**Subject:** RE: A/110/20/RES Land South of Water Lane Angmering Ap/17/OUT for the Bridge over the Black Ditch providing access to the approved development.

With regard to Planning Application A/110/20/RES further information has become available since I submitted my representations.

The EYA 2018 report contains 24 maps titled Case A, which is pre-development and Case-B, which is post development.

3.1.2 Case-B: Post-development

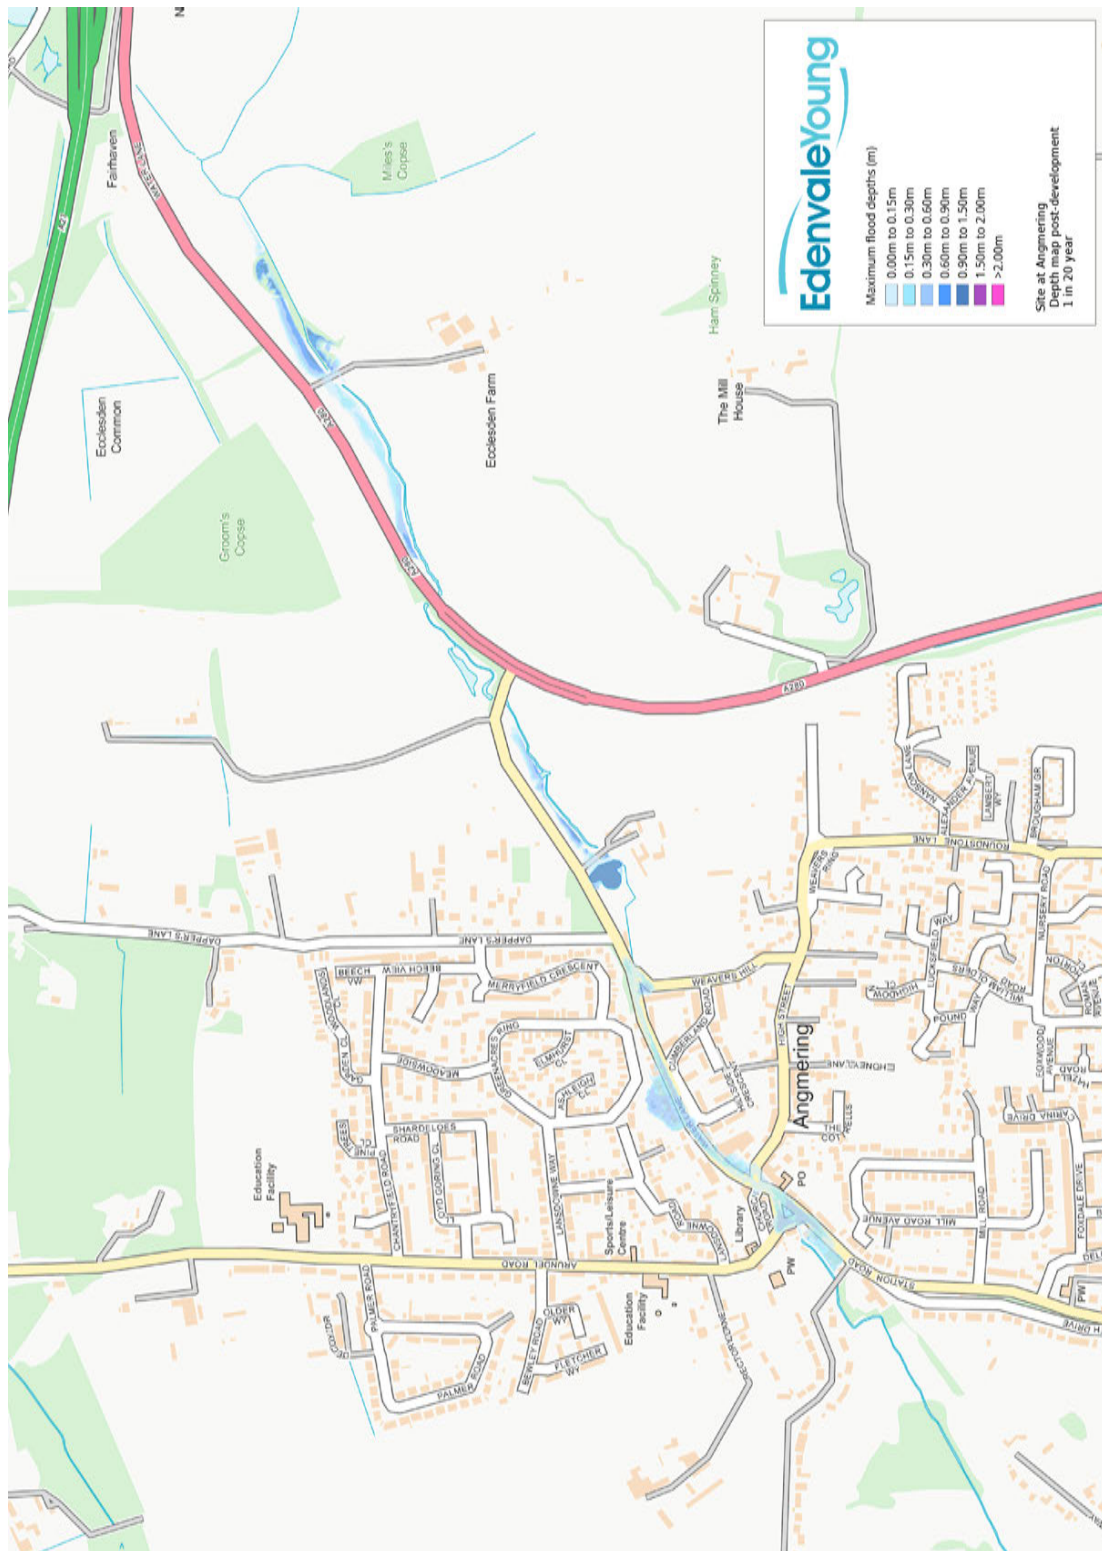
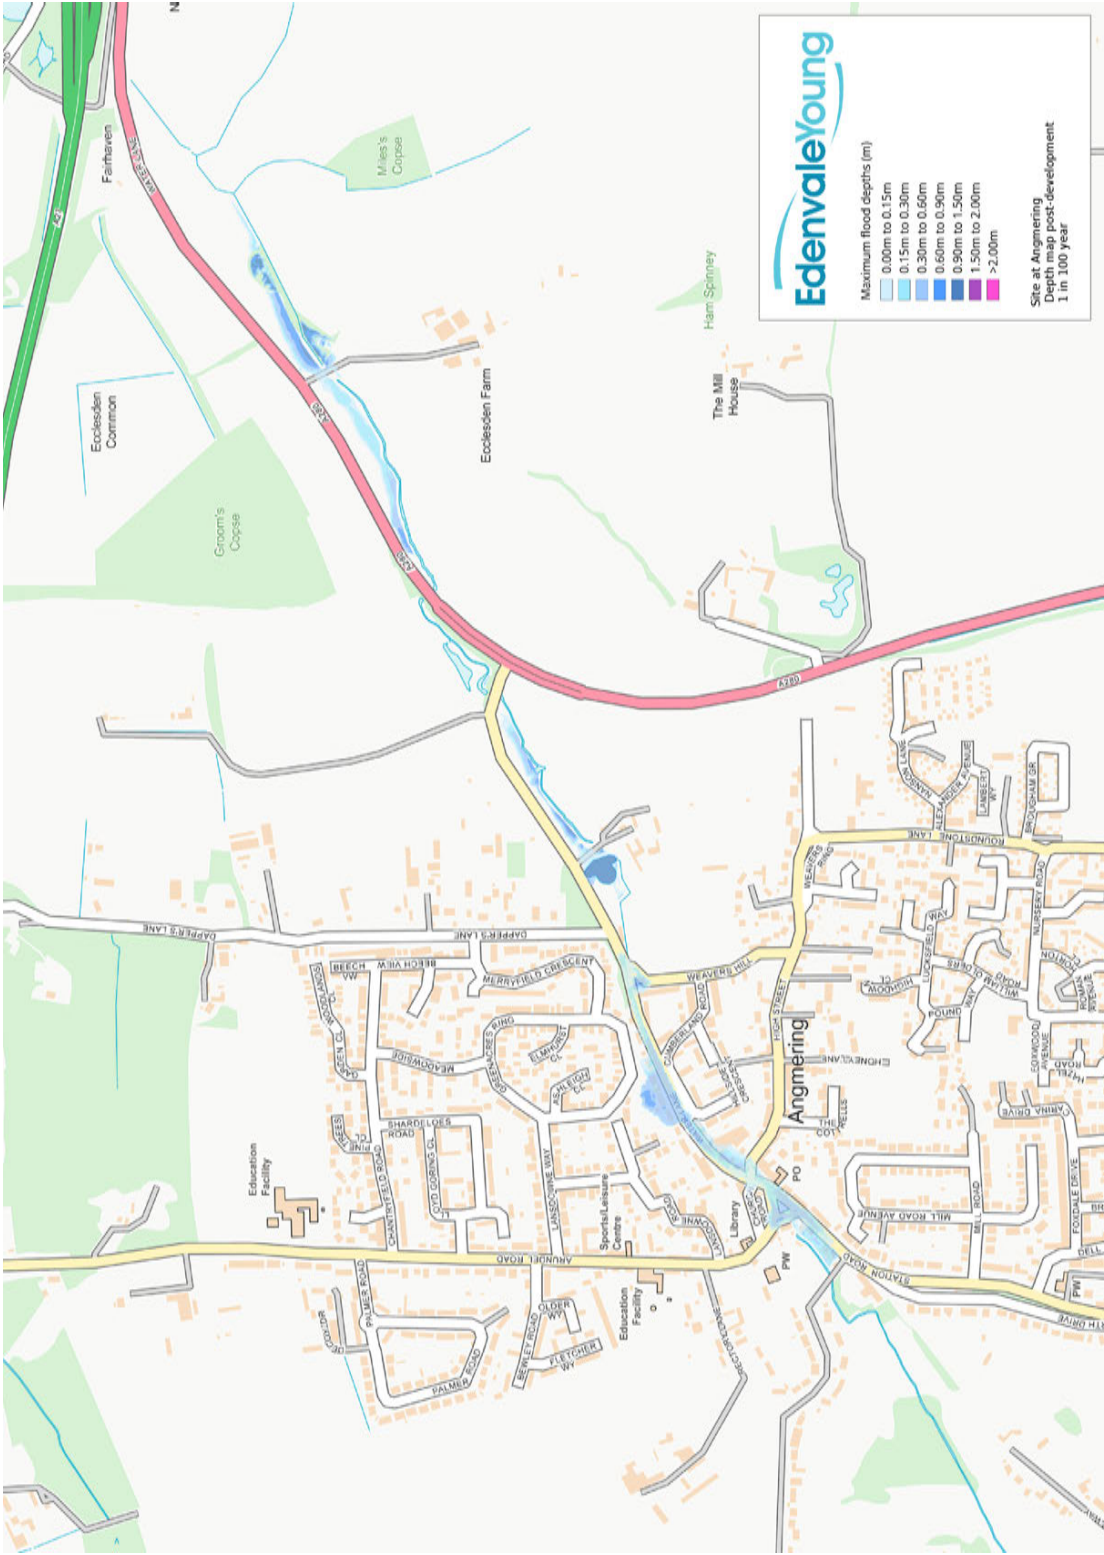
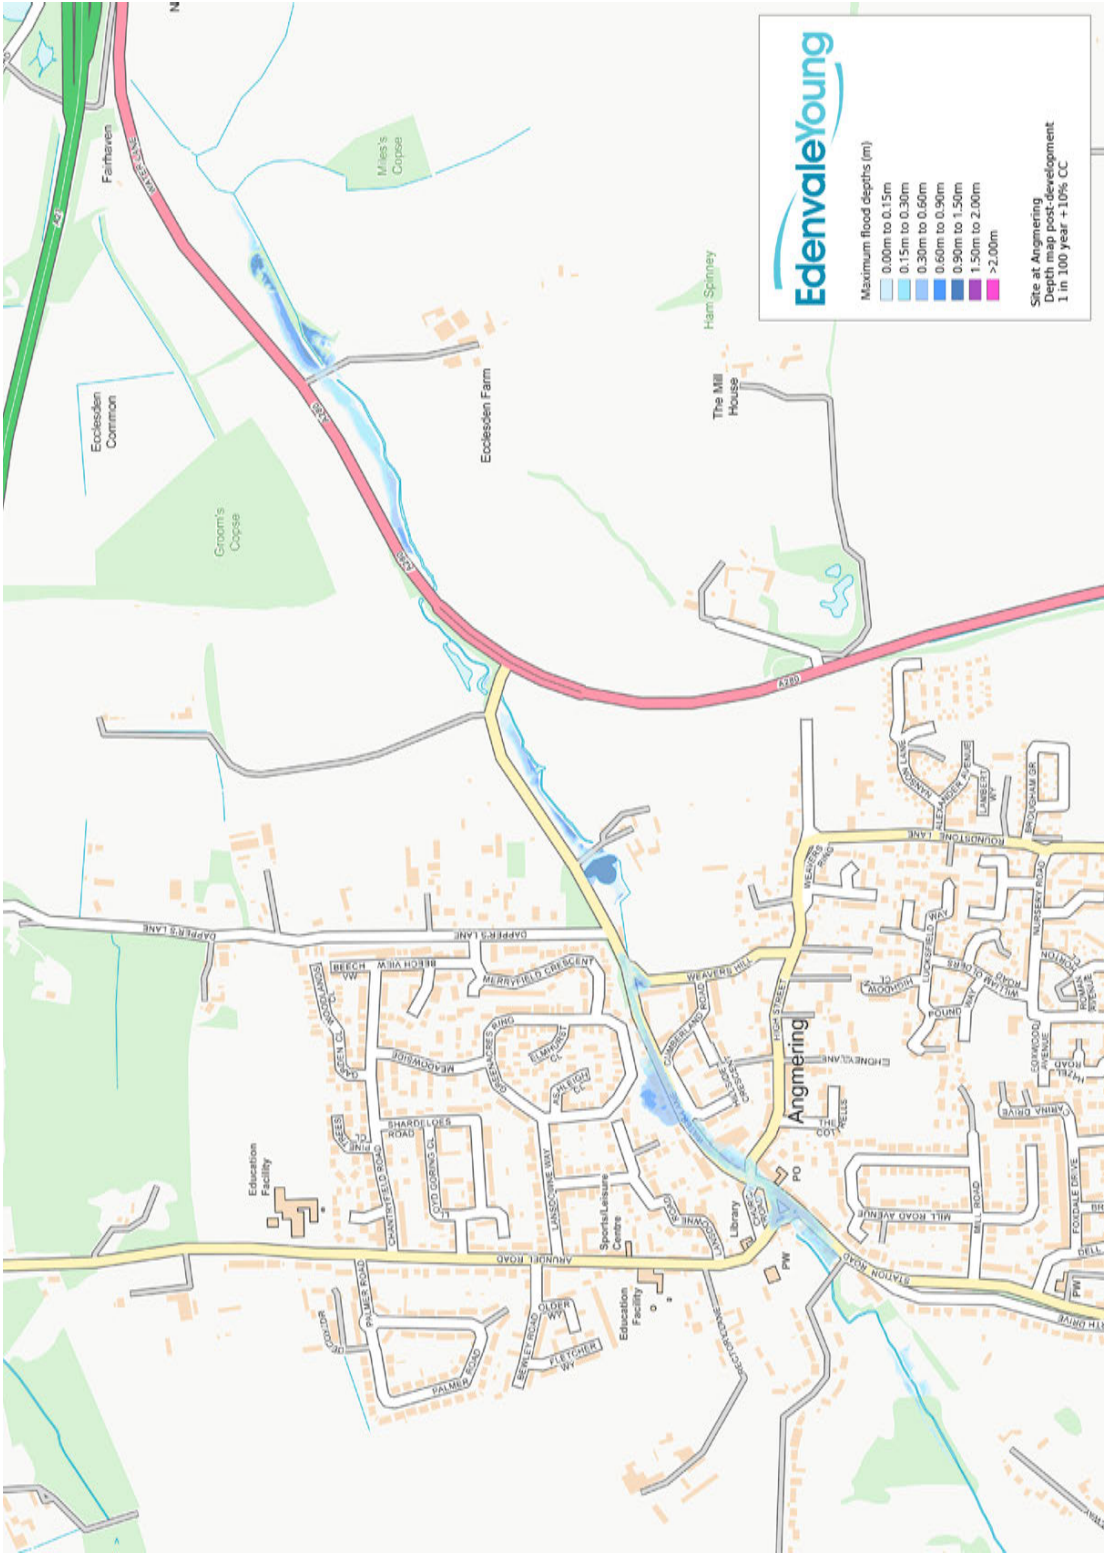
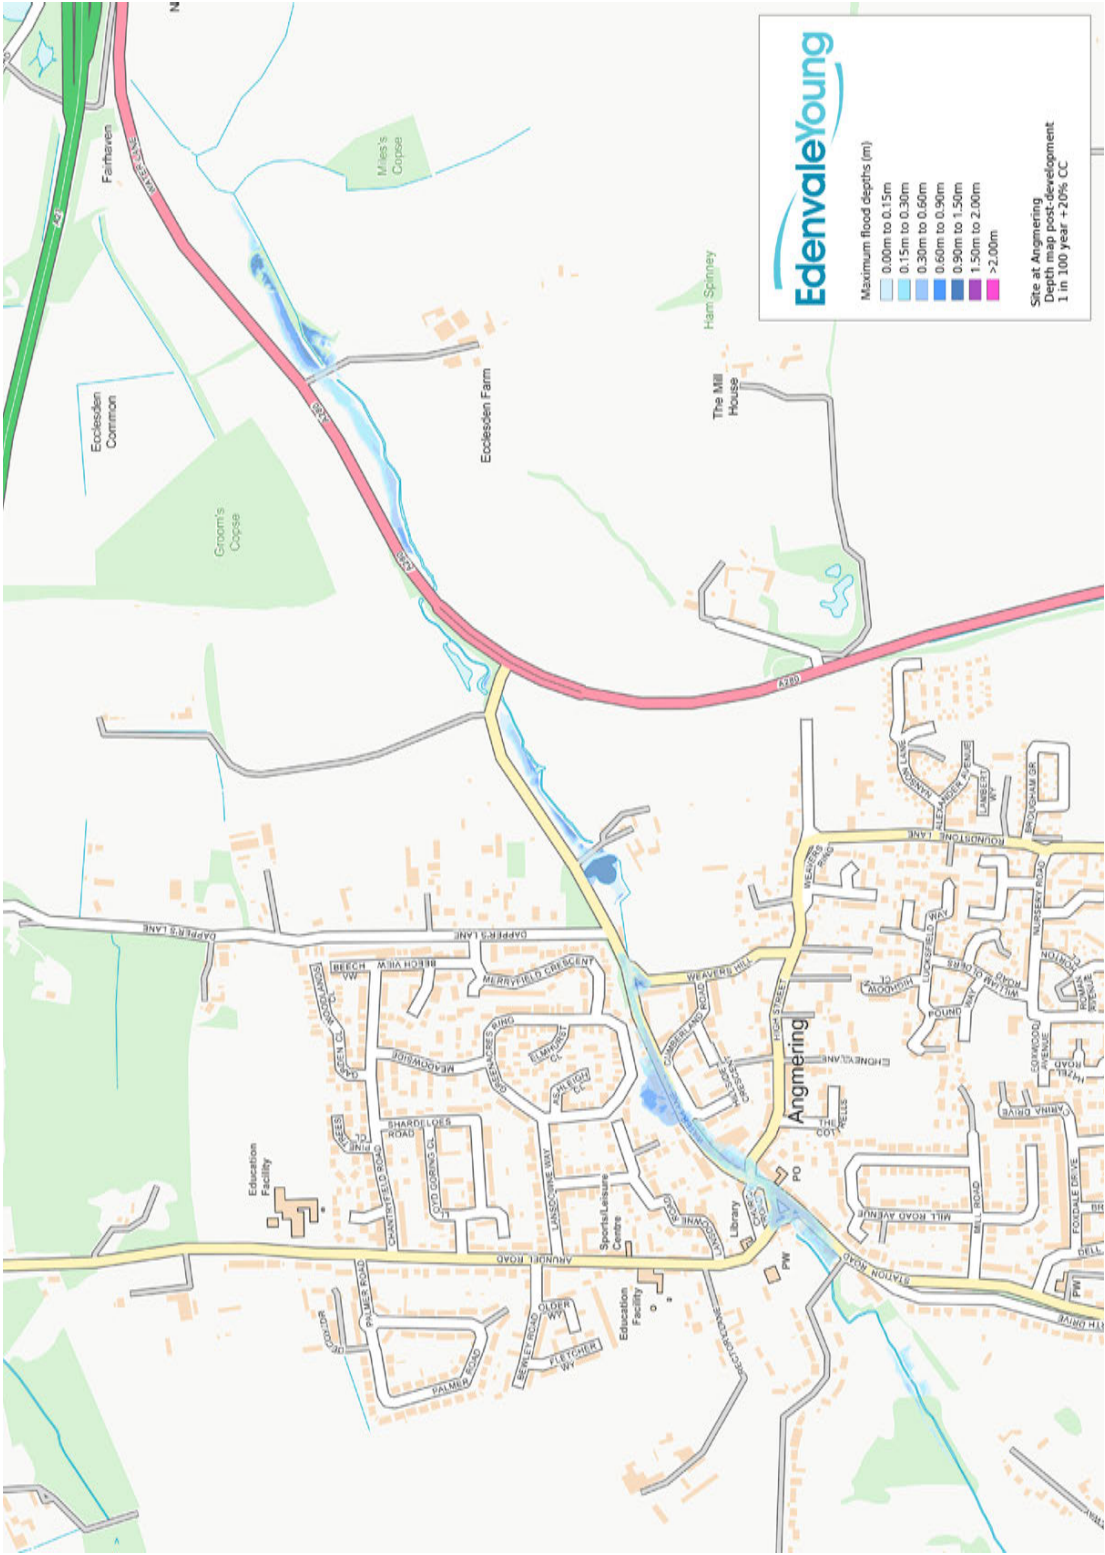
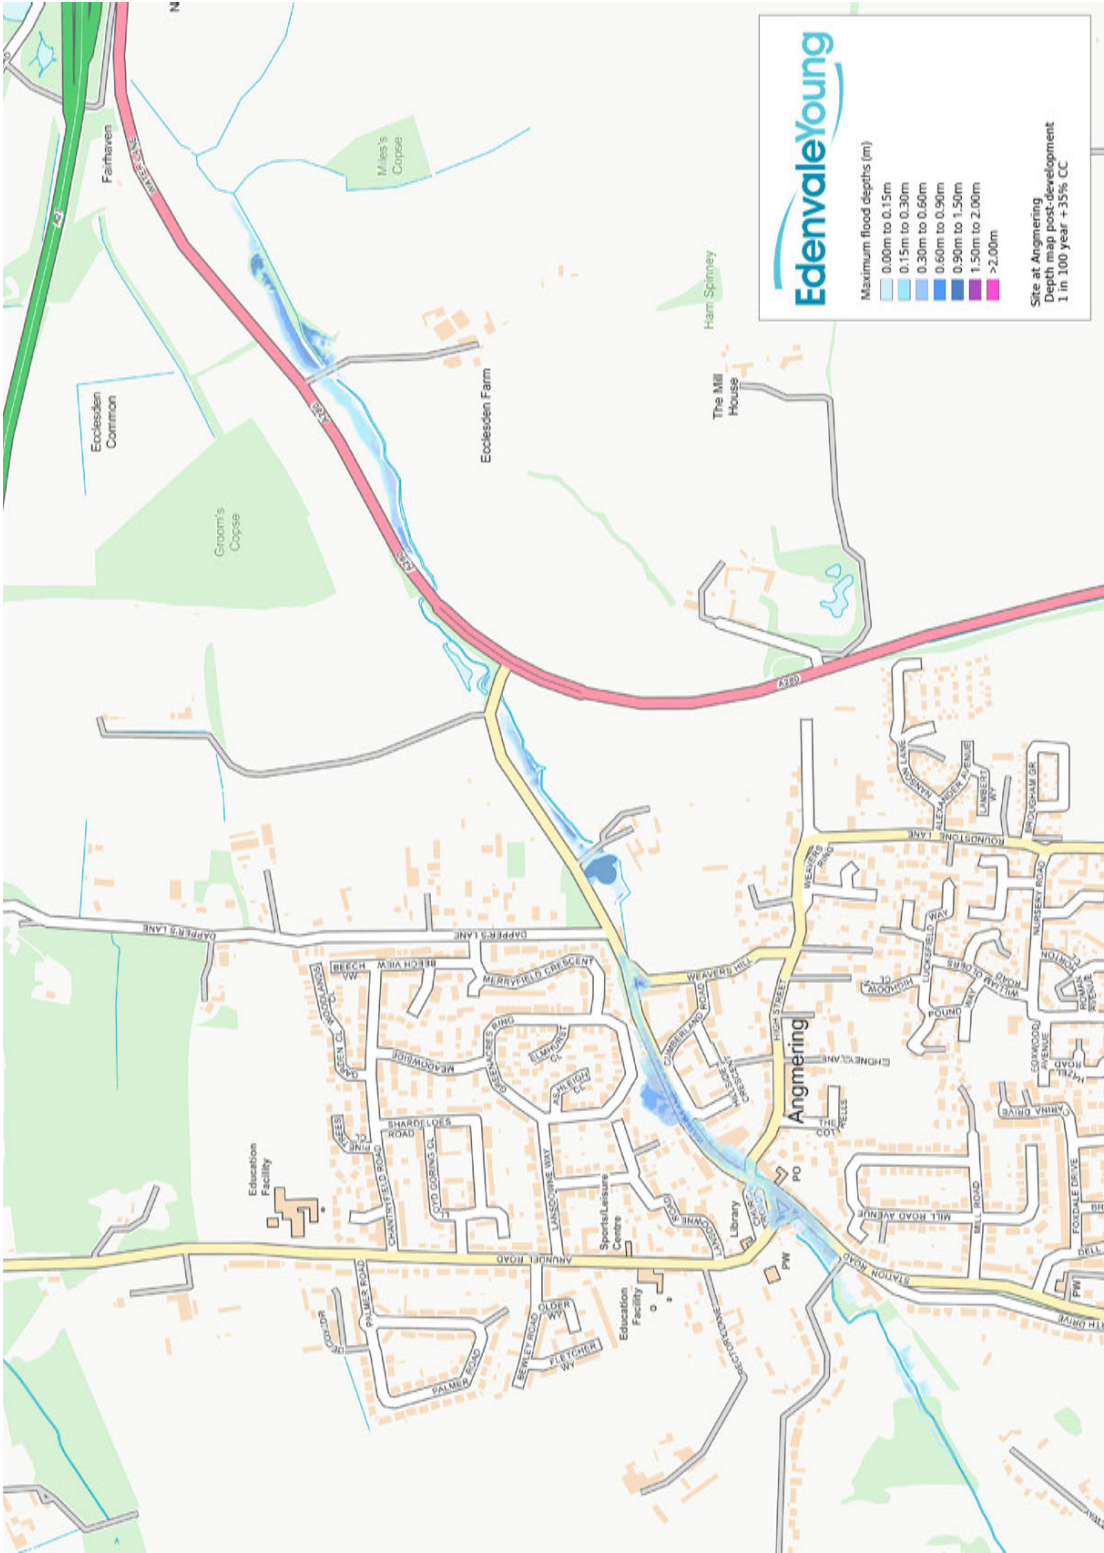
- The case B depth maps numbered 3.7 to 3.12 are headed 'Pre-development' when it seems they should be 'Post-development'.
- The case B level maps numbered 3.19 to 3.24 are also headed 'Pre-development' when it seems they should be 'Post-development'.
